### MEMORANDUM

**TO:** All Staff  
**FROM:** Public Works Plan Review Team  
**DATE:** November 4, 2025- UPDATE 2/18/2026  
**SUBJECT:** BL-25-00016 Andersen

**ANDERSEN BLA
SITE PLAN**

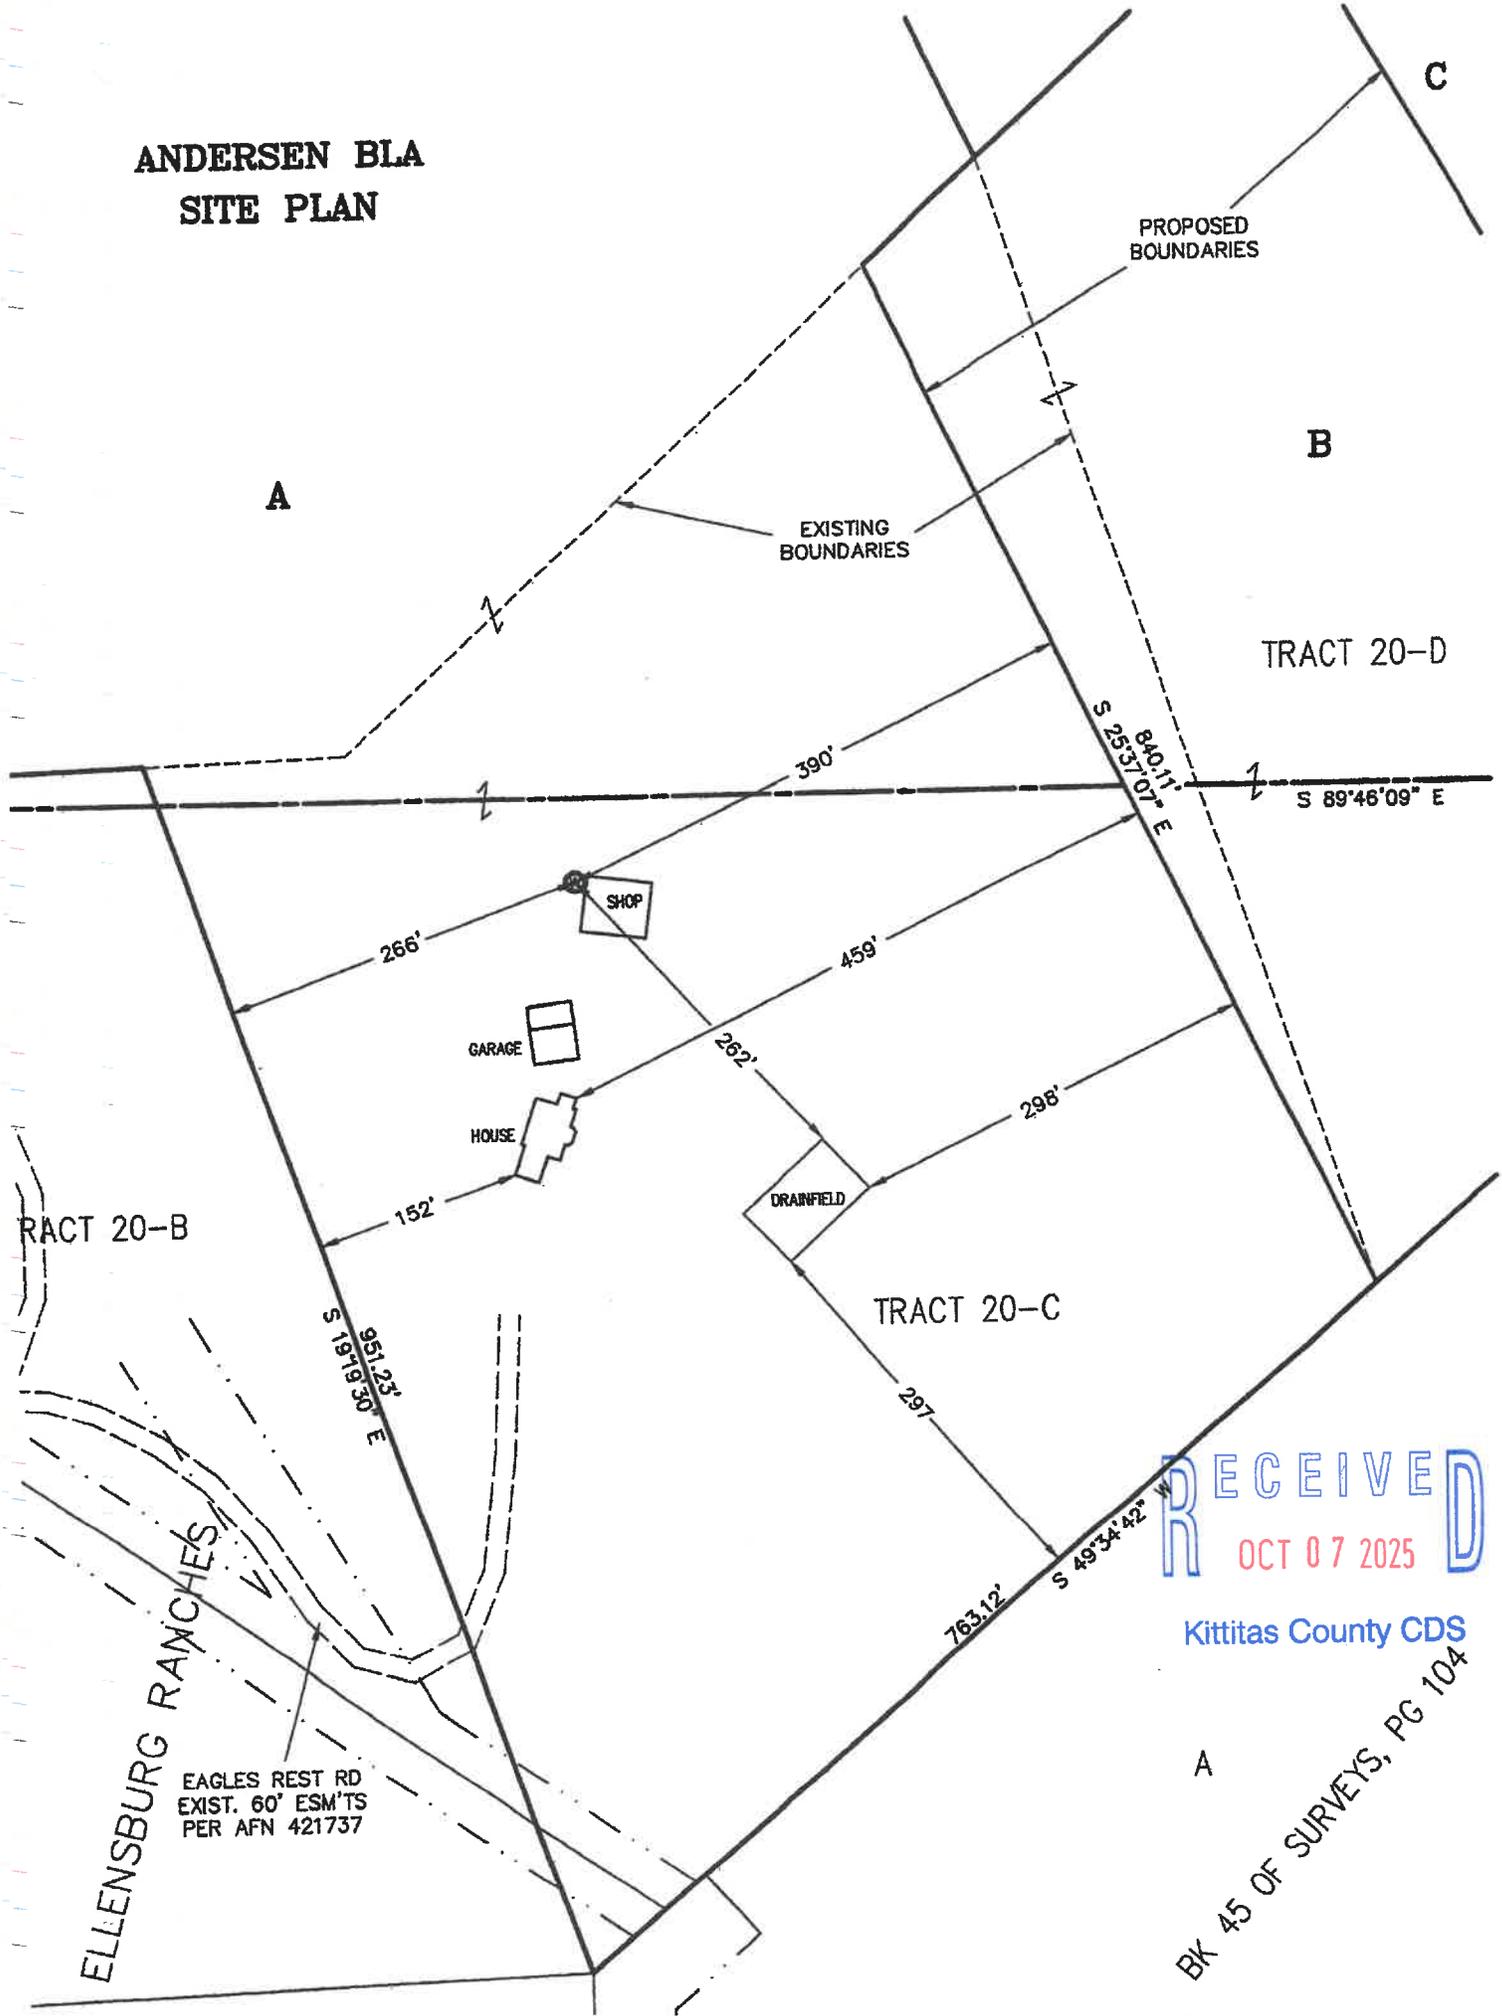
<b>ENGINEERING</b>	<p>Except as exempted in KCC 14.05.060, no grading or filling upon a site involving more than one hundred (100) cubic yards shall be performed without a grading permit from the County Engineer or Public Works designee (KCC 14.05.050). An application for grading in excess of five hundred (500) cubic yards shall be accompanied by an engineered grading plan (KCC 14.05.080). (CBP)</p>
<b>SURVEY</b>	<p>Waiting for final application/Record of Survey before making comments</p> <p>UPDATE 02/18/2026</p> <ol style="list-style-type: none"> <li>1. Please show and label Eagles Nest Road through Parcel A. Please label this as a private road and include the surfacing material. If you choose to include the easement limits, please show the easement width.</li> <li>2. There is likely a structure on Parcel A, near the West boundary. Either show this, or notify the county that it is a trailer, concrete pad, or other non-structure.</li> </ol>

**SHEET 1 OF 2**

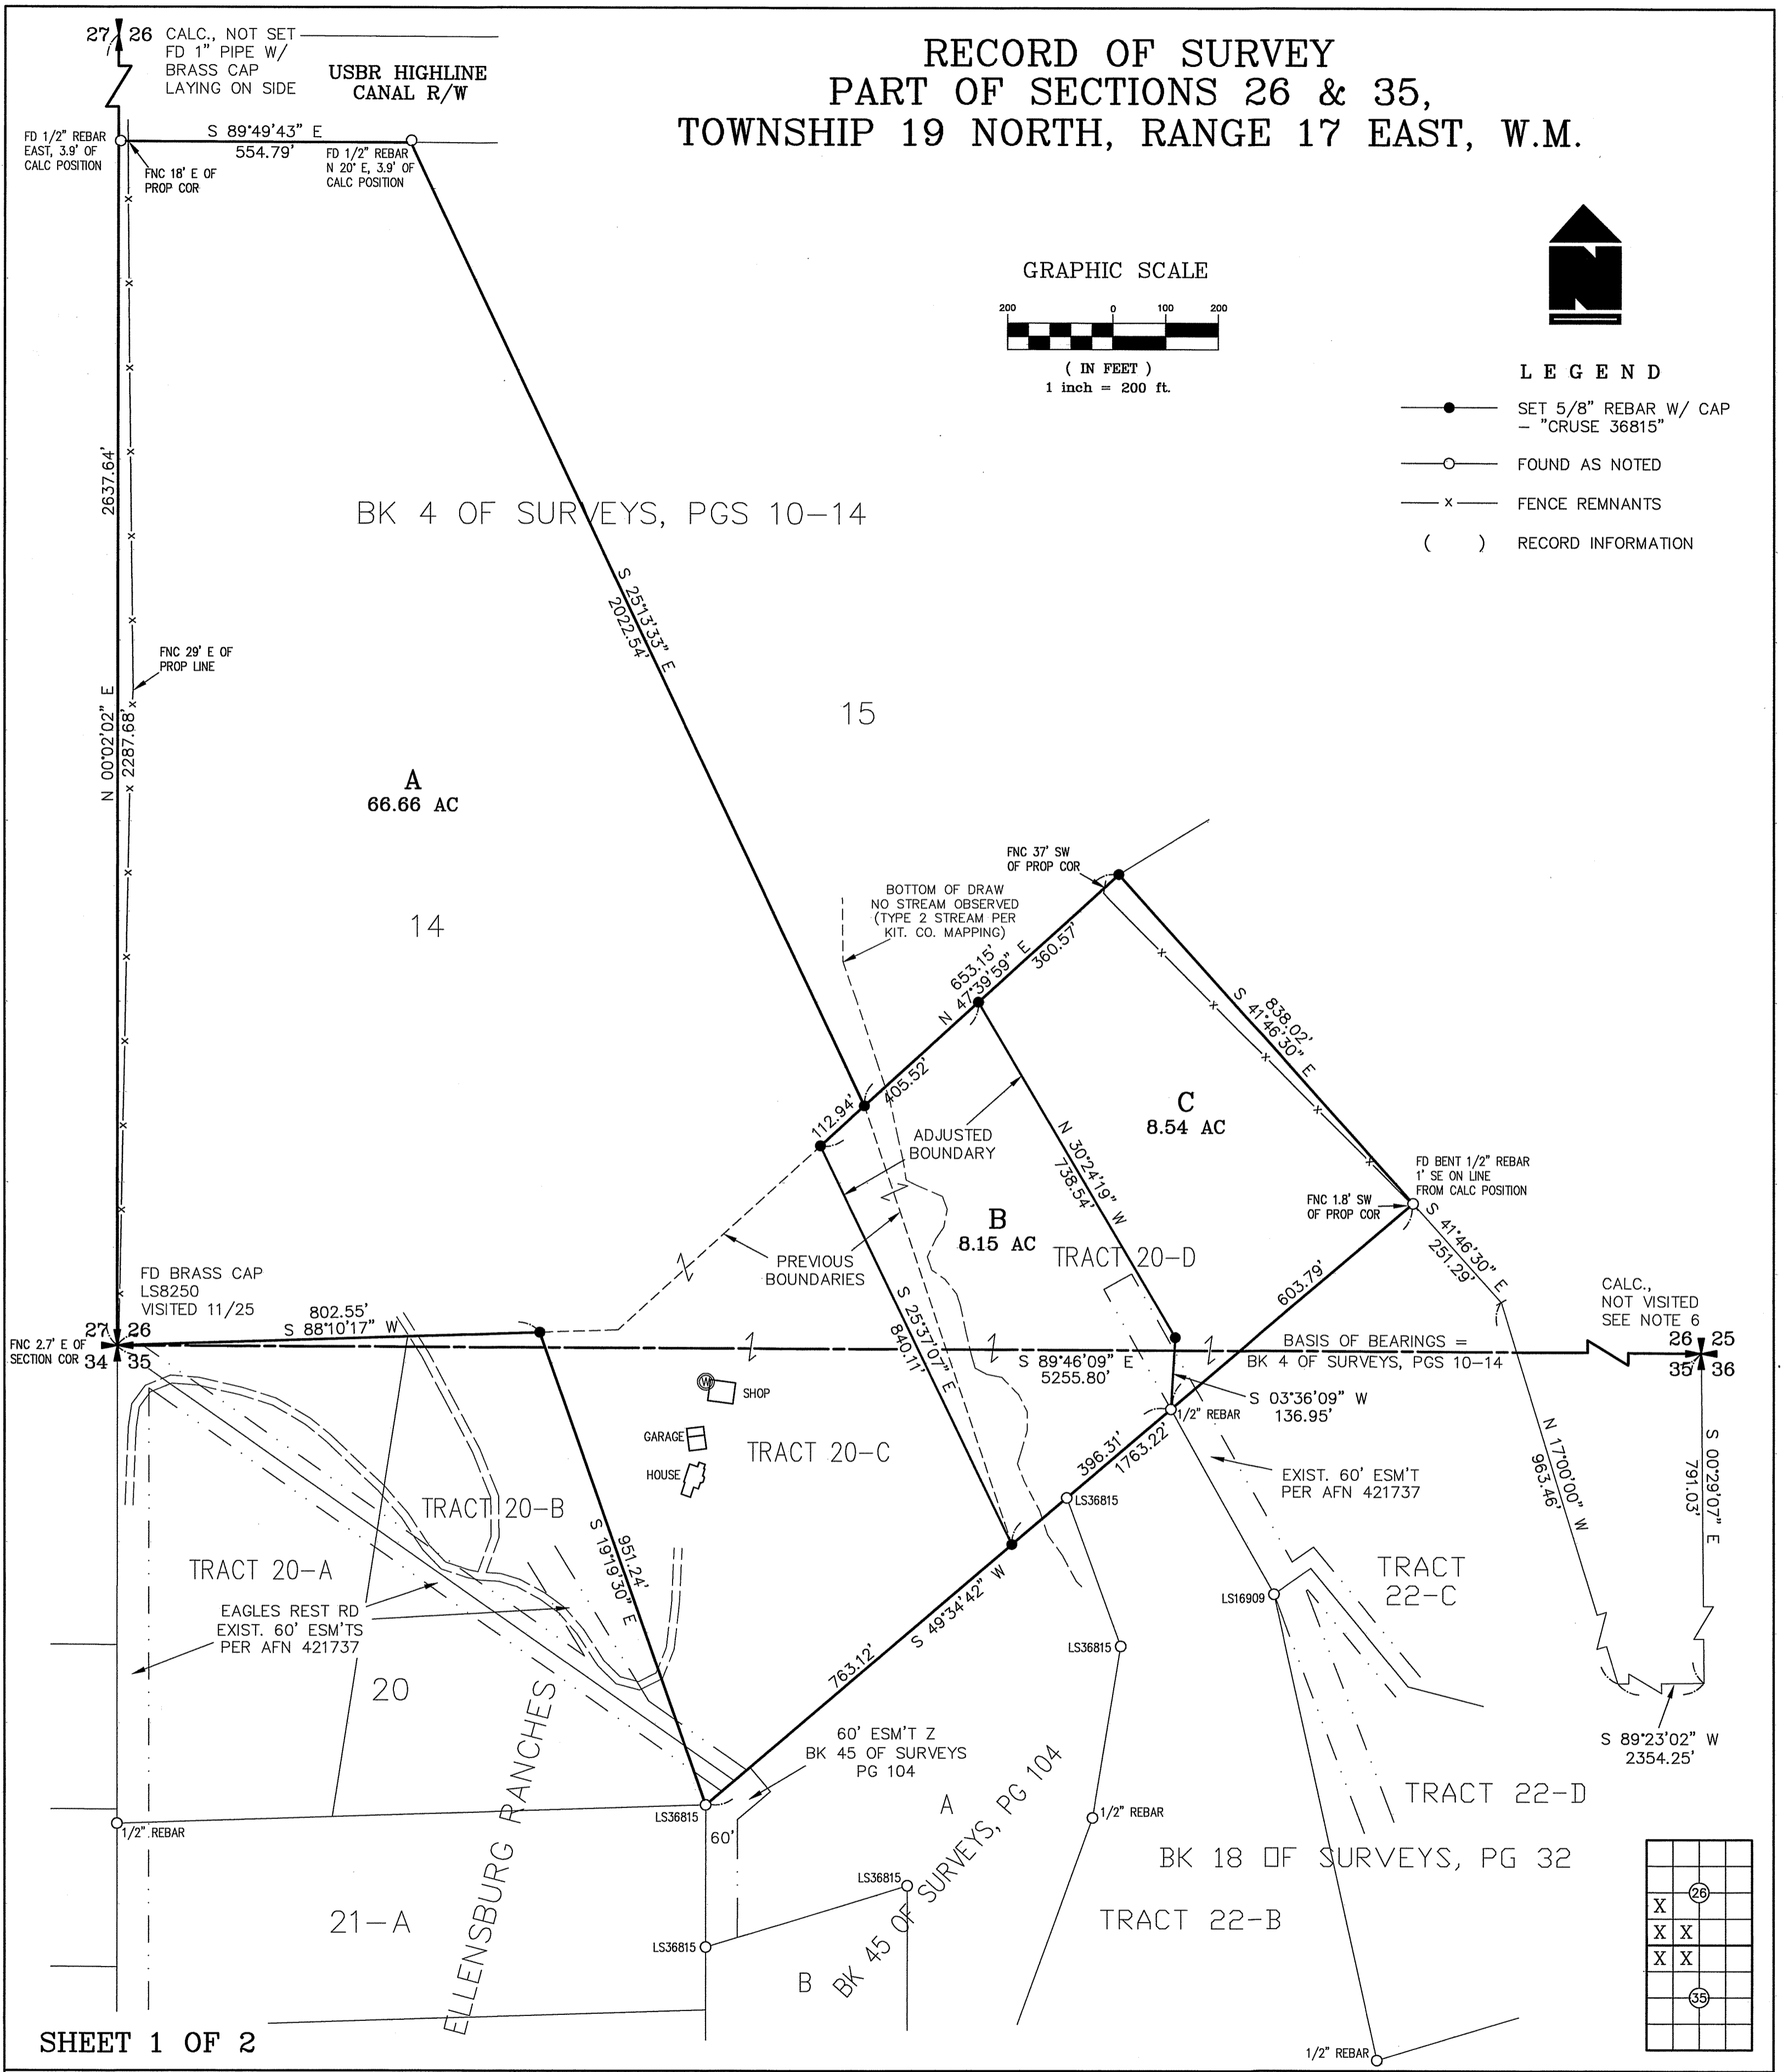
3. Note 5 does not meet the intent of RCW:58.09.090(1)(d)(iv), or WAC 332-130. While this code is being interpreted from whether a Record of Survey is required, it stands to reason that the same level of accuracy would be met on a Record of Survey. Please change this tolerance to 0.50' and label corners accordingly. NOTE: An opinion from DNR's Survey Advisory Board deeming the existing note as suitable would be an acceptable alternative to changing Note 5. (JT)
<b>TRANSPORTATION CONCURRENCY</b>	No transportation concurrency management requirement for this project.(RC)
<b>FLOOD</b>	No comments. (SC)
<b>WATER MITIGATION/ METERING</b>	No comments. (SC)
<b>AIRPORT</b>	No Comments. (RC)
